Our ref: 7033/2.7/SL

25th June 2020

Angels Nursery, Yapton

In response to your e-mail dated 16th June, please see below our responses in Green and our drawings and calculations enclosed for your approval.

PRECAST CONCRETE CONTROL CHAMBER

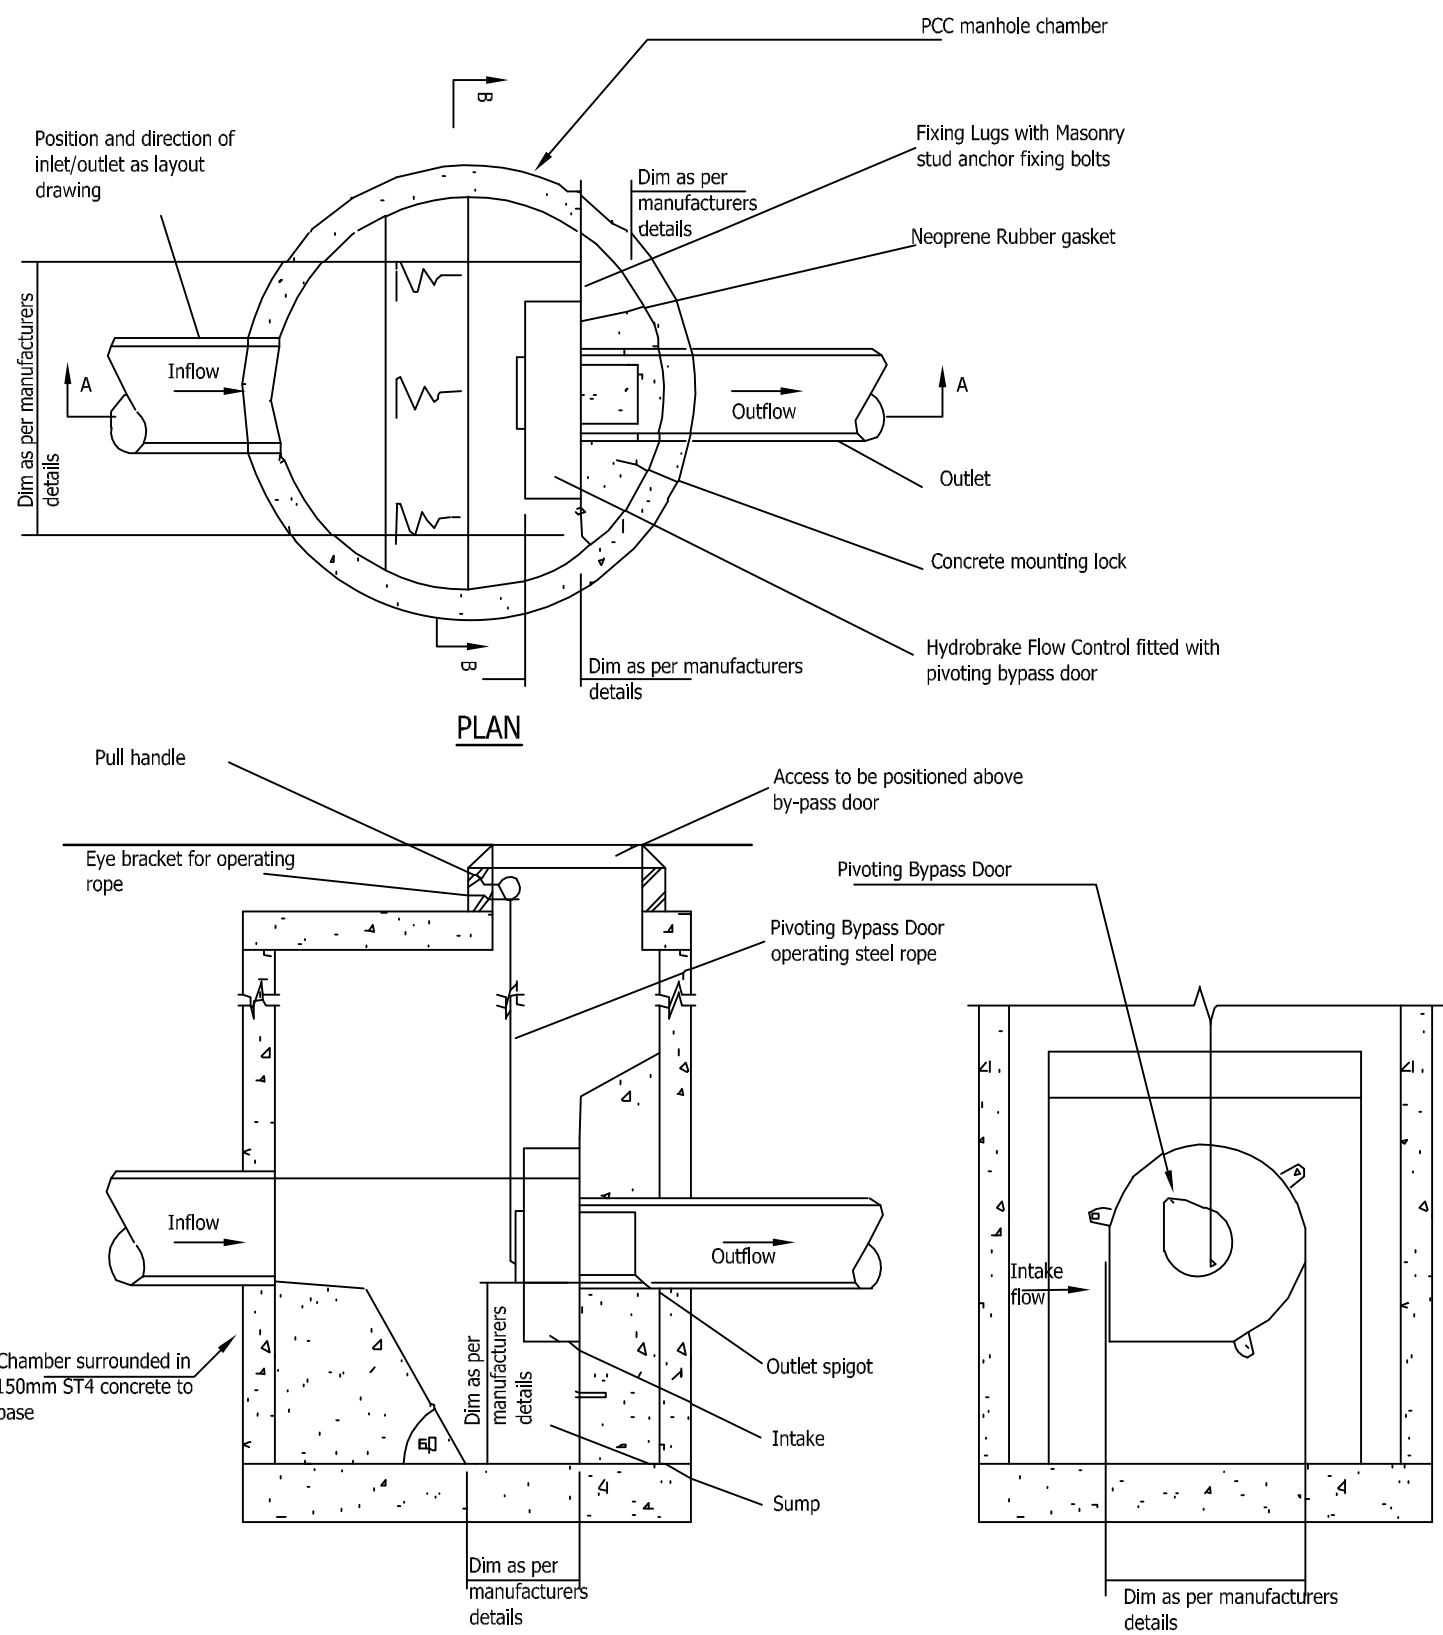
54. SMH control manhole on pond outlet – overflow pipe shown on plan? *Overflow not shown on detail. Please provide site specific detail. Revised on drawing 5102.*

64. Hydrobrake chamber detail – rings to be surrounded in 150mm thick concrete and to be extended down to the bottom of its base. All to be ST4 concrete. Add benching construction notes and include hydro international details referred to. *Note is not clear that surround extends to bottom of base, benching note missing, hydro international details not included.* See revised detail on drawing 5102.

DISTRIBUTION/COLLECTOR TANK DETAIL WITHIN TANKED PERMEABLE PAVING (MARKED DT ON LAYOUT)

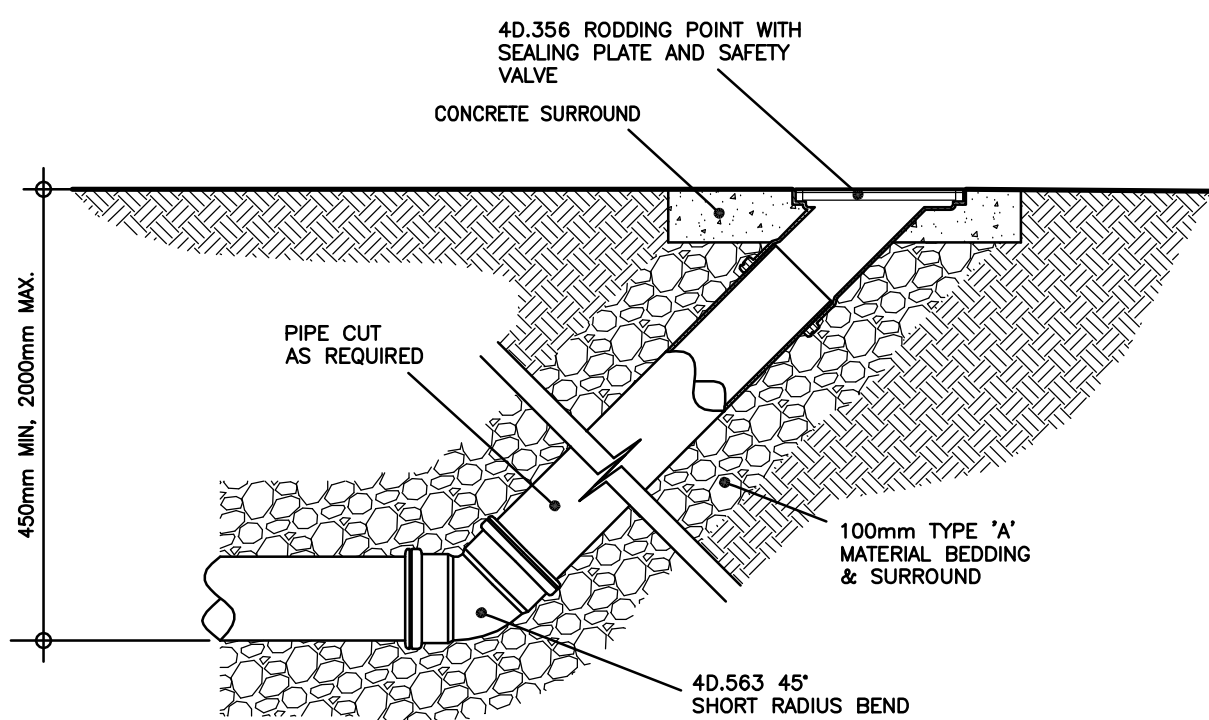
70. Provide sloping formation permeable paving detail. *Please provide.* The section through permeable paving and distribution tanks shown on drawing 5101 is applicable to both level and sloping formations. I have added a note this effect on the detail now.

73. Provide construction detail distribution tanks on permeable paving outlets. *Please make it clear that invert level of outlet tanks is at formation level.* Note added to DT detail on drg 5101.

CONCRETE BAFFLE DETAIL

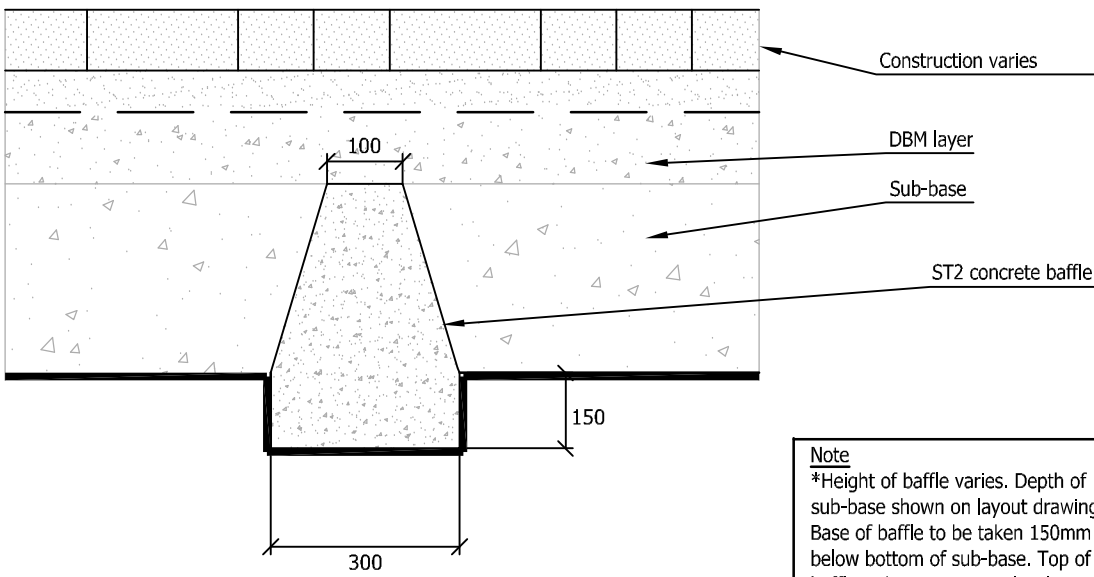
71. ~~Baffle detail—Make it clear that the top of the concrete is level with the top of the sub base.~~ *Okay.*
72. Provide pond construction detail including impermeable liner and any necessary anti-buoyancy measures. Floatation calcs to be provided. *Please provide.* Pond sections now shown on drawing 5108.

ADOPTED OUTFALL HEADWALL
SCALE 1:25

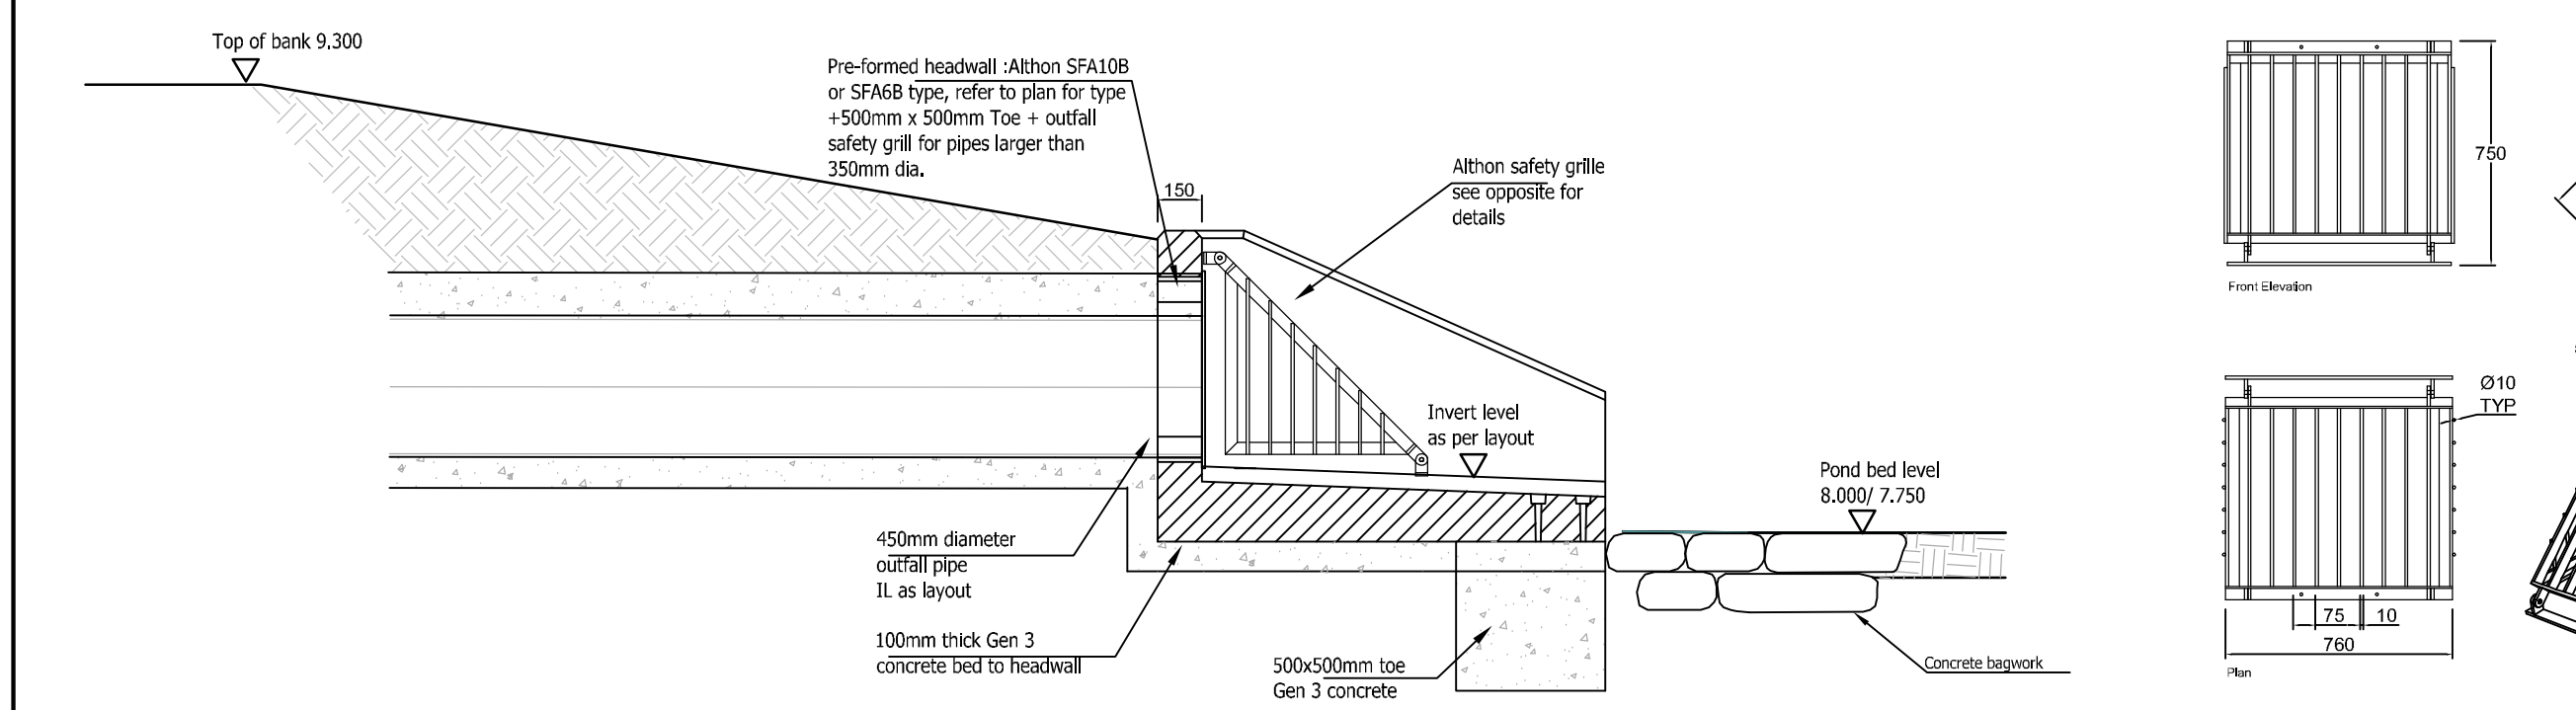
50. 450mm inlet pipes to pond to have 'cranked' grilles. *Please provide cranked grilles. See revised detail on drawing 5105.*
51. Overflow at S11 – is this required? *Please provide commentary. No, this has been removed.*

52. ~~Pond outlet pipe specified as 150mm and 225mm diameter?~~ *Okay.*
53. Pond outlet headwall requires cranked grille – may need to adjust proposed headwall construction to suit. *Please provide cranked grille. See revised detail on drawing 5105.*

66. ~~Provide catch pit detail for all manholes immediately upstream of permeable paving connections.~~ *Okay.*
67. Adoptable outfall headwall detail – remove flat grille and specify cranked including bar spacings, etc. Incorporate Athlon detailed drawing within this drawing. Pond bed level shown as 7.800 but 7.900 on plans. *Please address points.* Pond base level is shown as 8.000 on plan with a reduced wet base level of 7.750. The detail has been revised to show a sloped Althon Trash screen.

65. PCC ring catchpit detail – unsure if this type is being specified anywhere? If, so detail where and include brickwork under manhole cover/frame and extend concrete surround up to top of cover slab. Specify ring diameter. *Unclear as to where specified, include MH schedule.* The Highway chambers at the northern end of the access road are catchpits. MH schedule has been added to the latest layout.
